Planning Officer: Mr F Gardner
Planning Application Ref: LU/229/19/T
Location: Pharos Quay, River Road, Littlehampton, BN17 5BF
Description of works: Various works to 7no. sycamore trees and 5no. Himalayan birch trees
Reasons Given: To achieve adequate clearance for vehicles/pedestrians and from buildings

PLAN 1

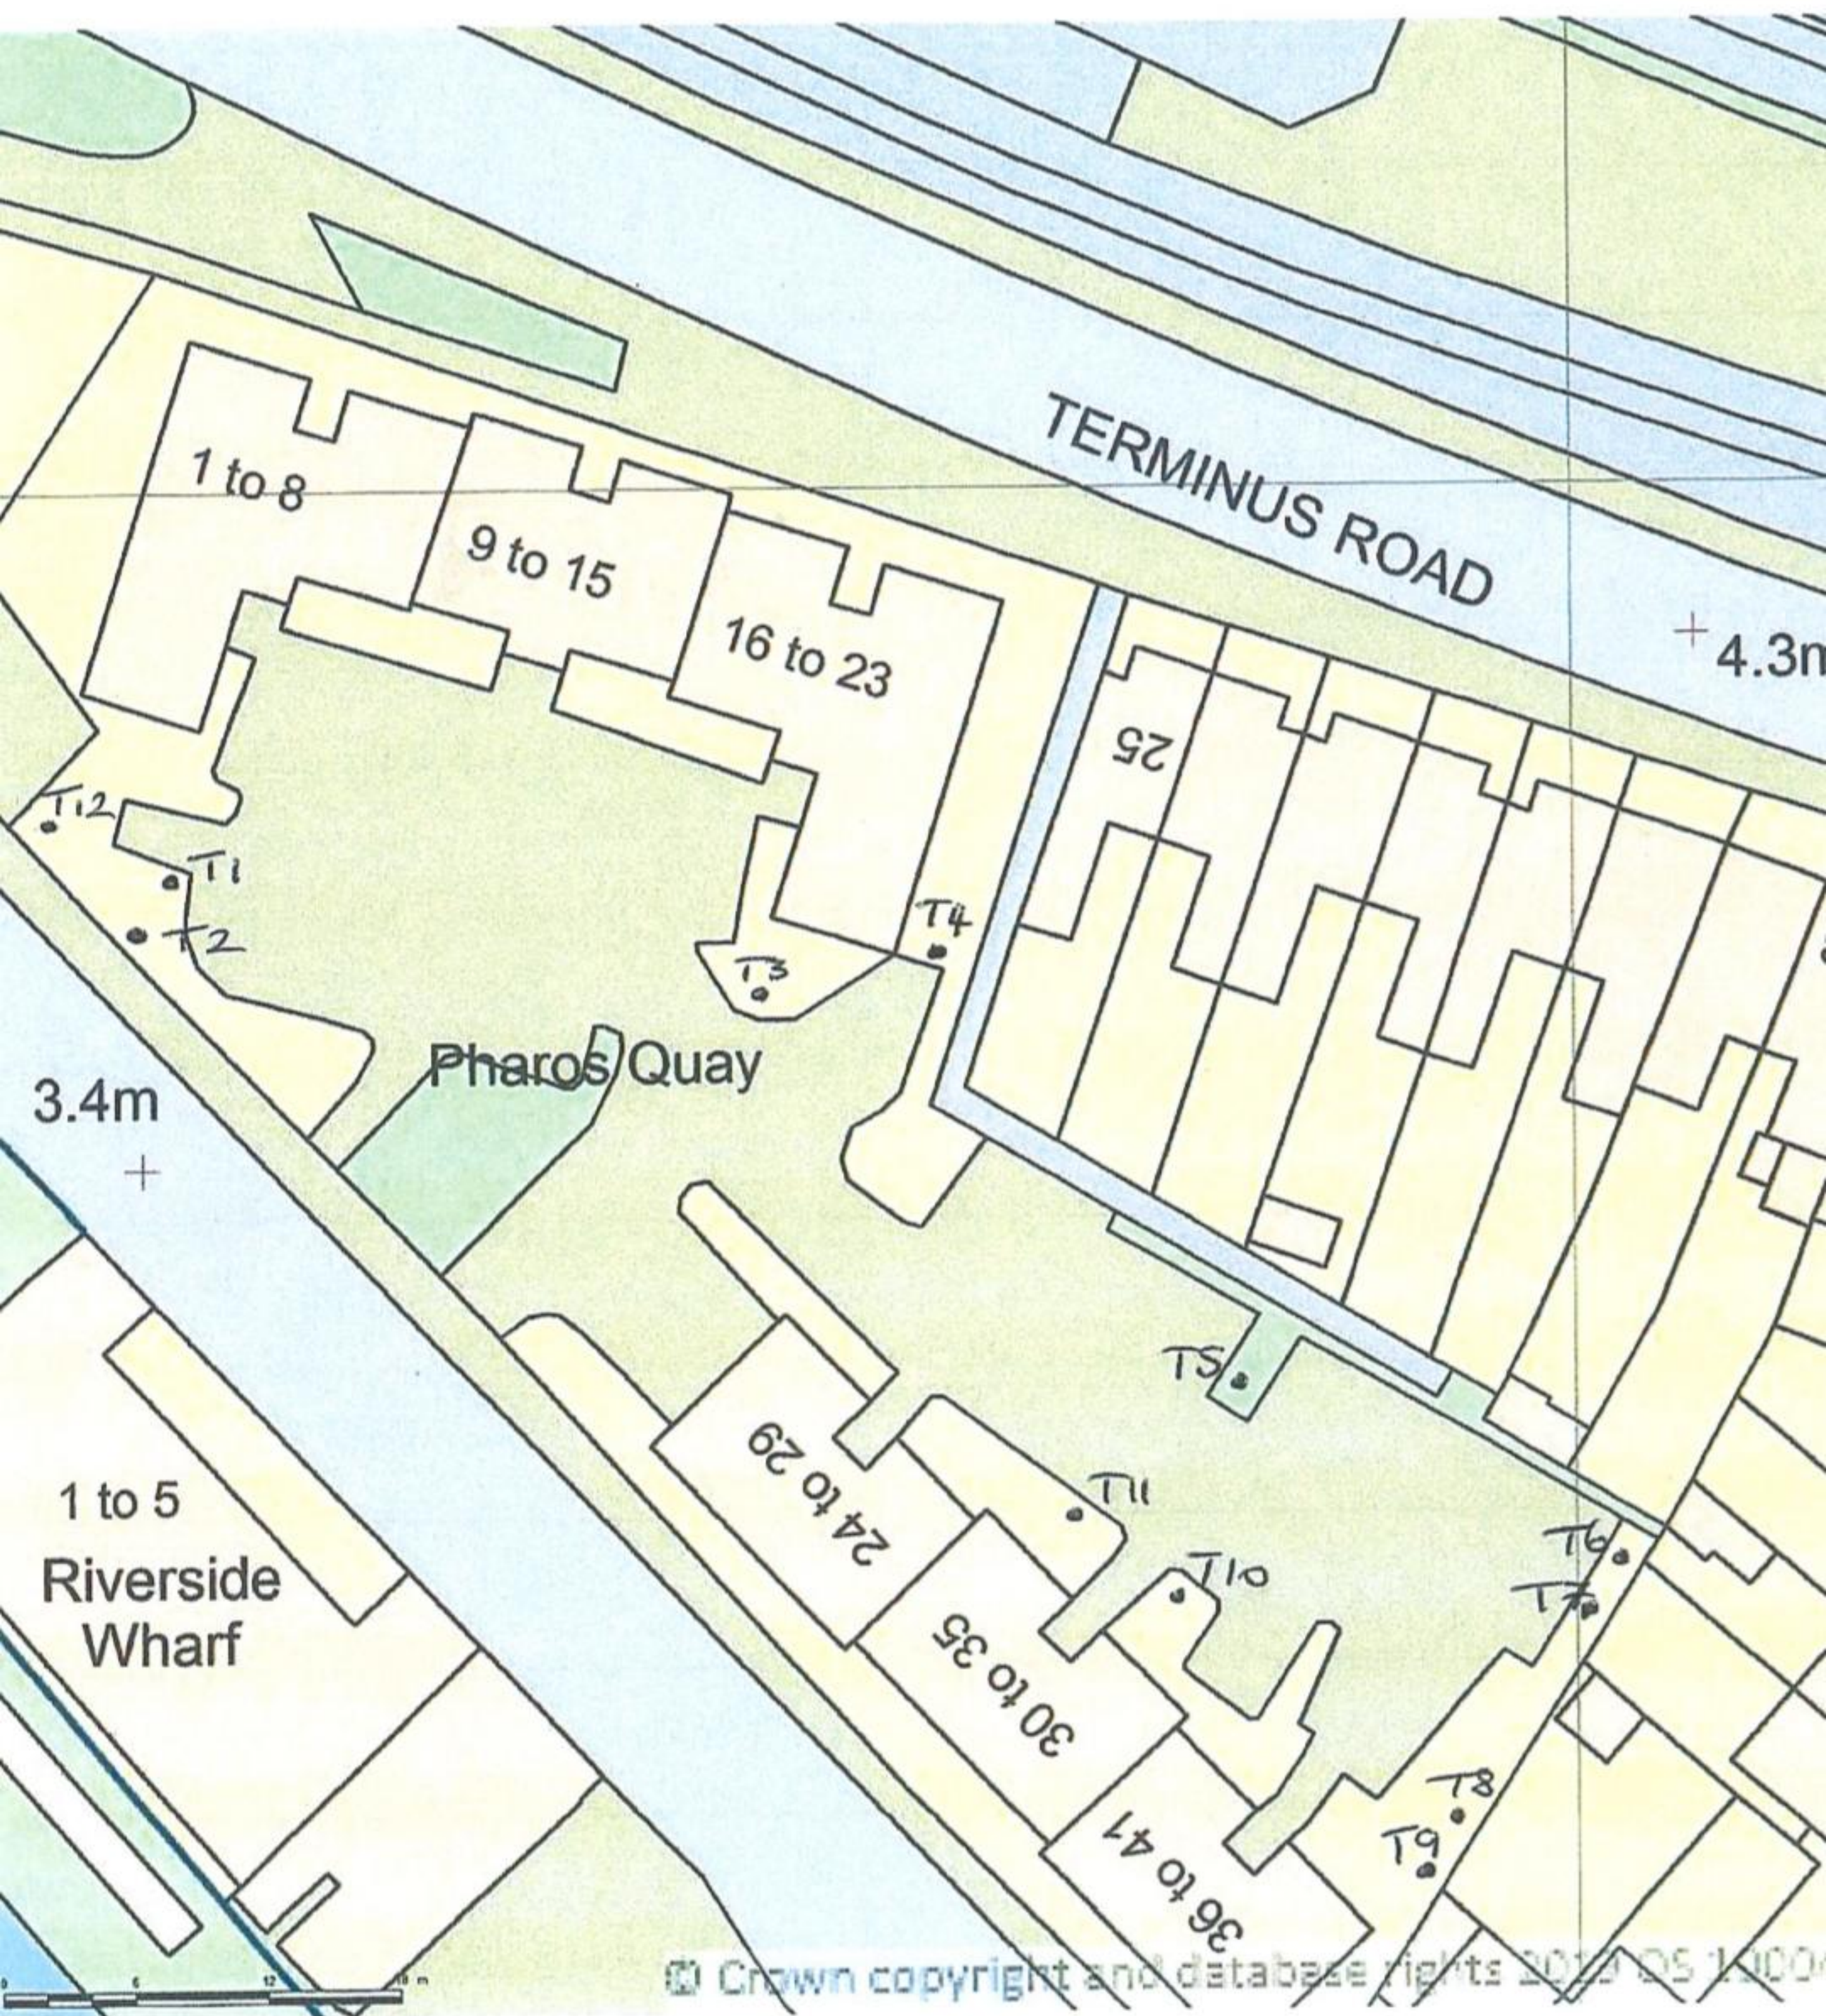
- The exception is T4 which has been proposed for removal. There is evidence of some crown dieback but only of minor extent at my time of inspection. If the tree is in serious decline so as to require removal, then there will be no significant loss of public amenity and a replacement tree can be planted.

- Once the tree (T4) has been felled (and either grubbed or ground out) then a replacement tree is to be planted in the same place or nearby and to within 4metres. The applicant must advise the local planning authority when this has been carried out.

This is to be of Standard Nursery Stock proportions (10-12cm girth & 2m to 3m overall height) supported on a 'short stake' system with appropriate securing ties and pads.

It is to be planted within 12 months of the removal of the birch tree (T4).
